An
Coimisiún
Pleanála

Record of Meeting ACP-324354-26 (PCX)

Case Reference / Description	Proposed 385 MW Open Cycle Gas Turbine (OCGT) Plant at the Barrigone Quarry Site located at the Roadstone Barrigone Quarry, Askeaton, Co. Limerick.		
Case Type	Pre-application consultation		
1st / 2nd / 3rd / 4th Meeting	1 st Meeting Record		
Date	14/07/2026	Start Time	11:00am
Location	MS Teams	End Time	12:05pm

Proposed Site Layout

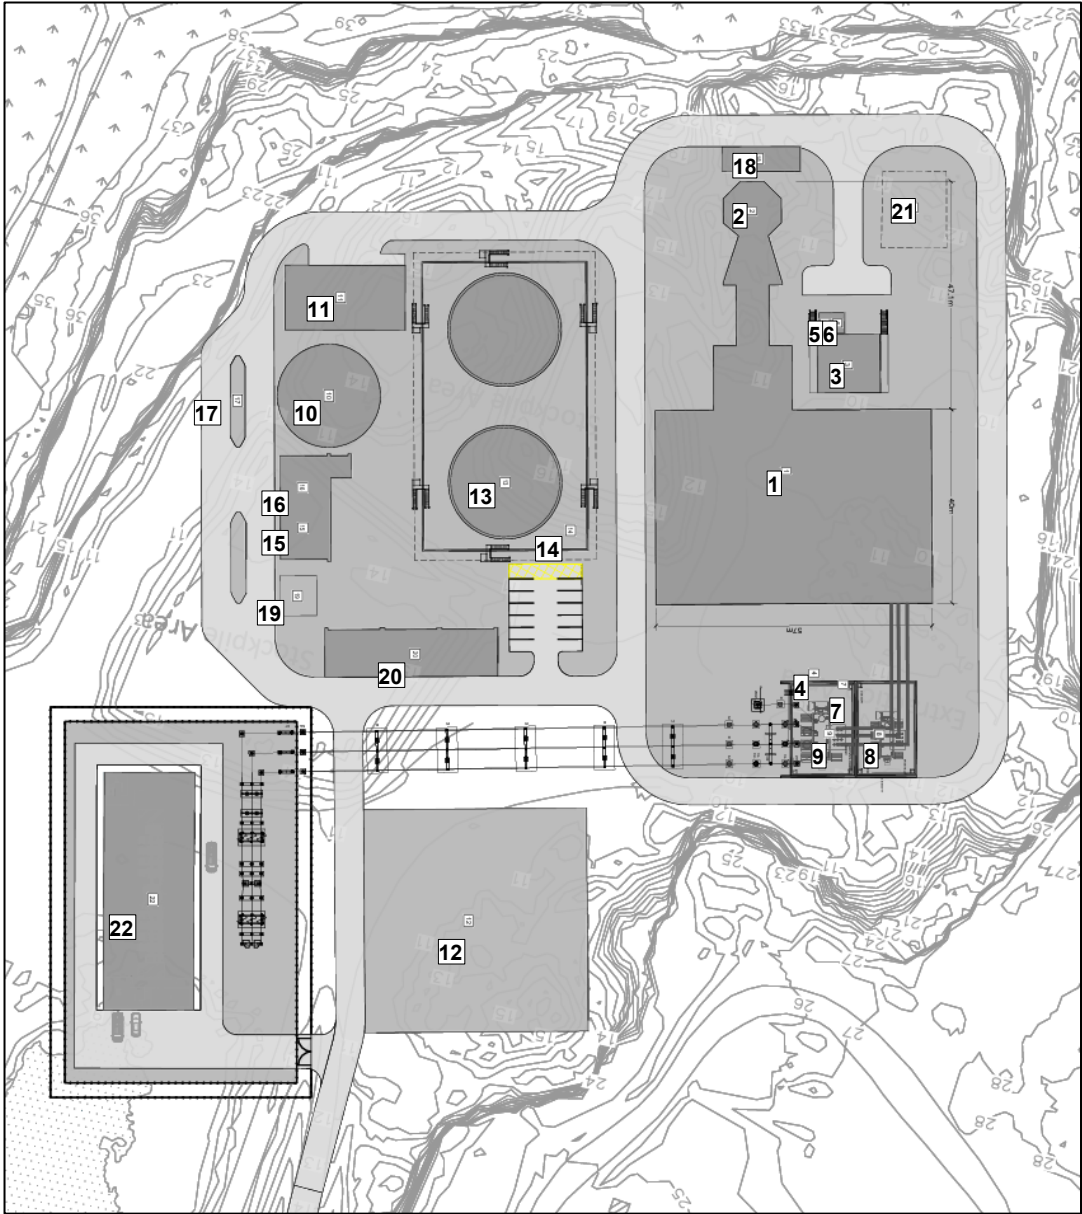
- The Commission's representatives enquired about the exhaust stack's height and air dispersion modelling, and whether the stack height is relative to the existing quarry floor level. The prospective applicant responded that air modelling is ongoing and the stack height is currently 30 metres relevant to existing quarry levels, which is accounted for in an air impact assessment and the air quality and the impacts on human health chapters in the EIAR.

Potential Woodland Areas – Visual Mitigation

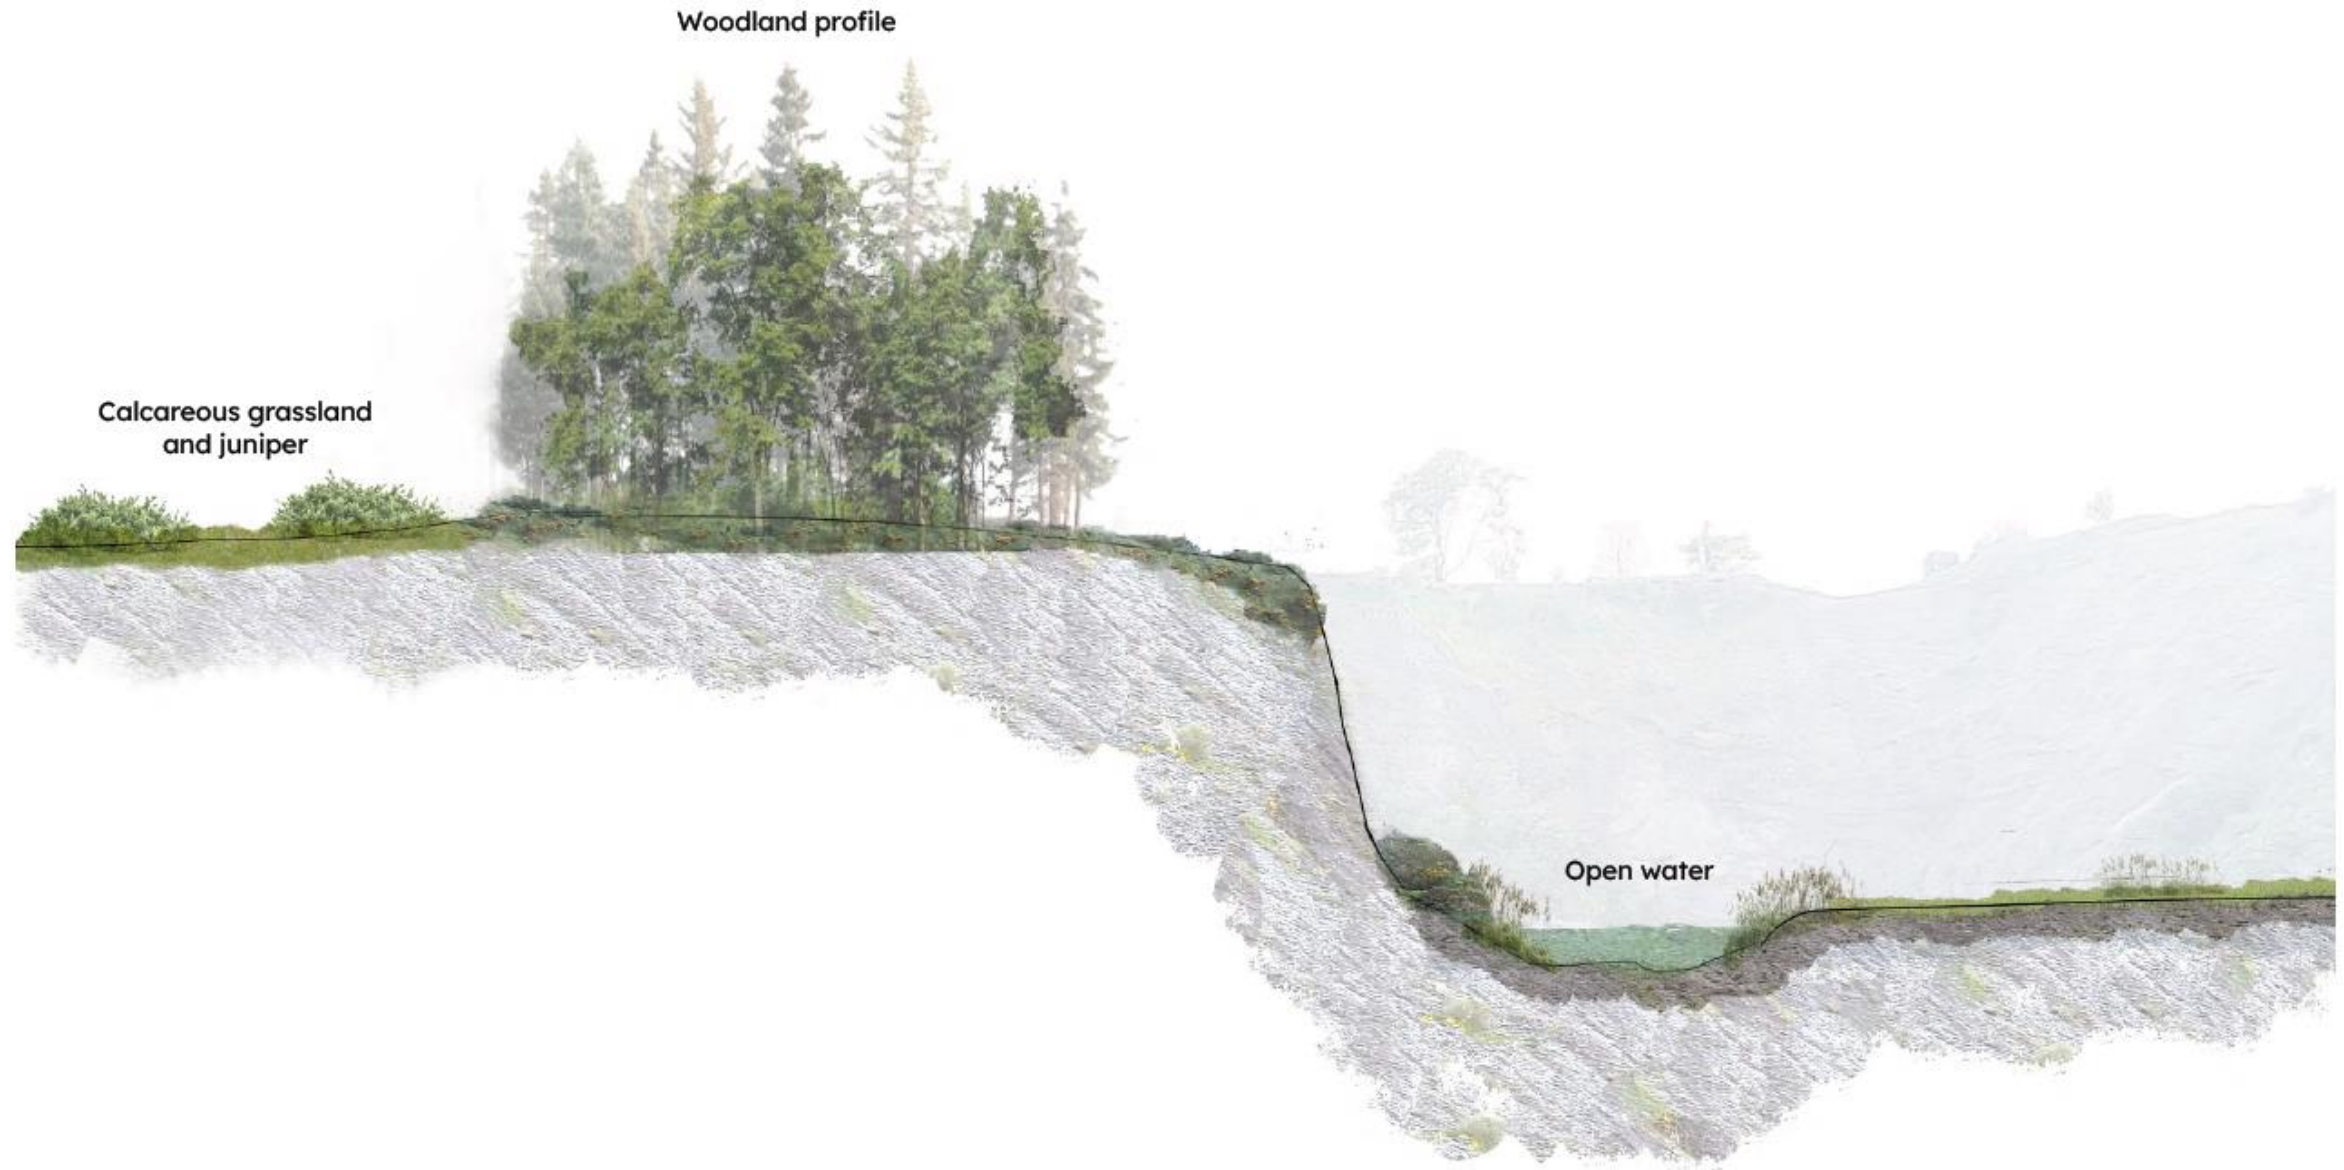
- The Commission's representatives queried the location of proposed native tree planting relative to the boundary of the Special Area of Conservation (SAC). The prospective applicant clarified that they would not be planting in the SAC and instead they would plant within the buffer areas between the SAC boundary and the red line boundary.
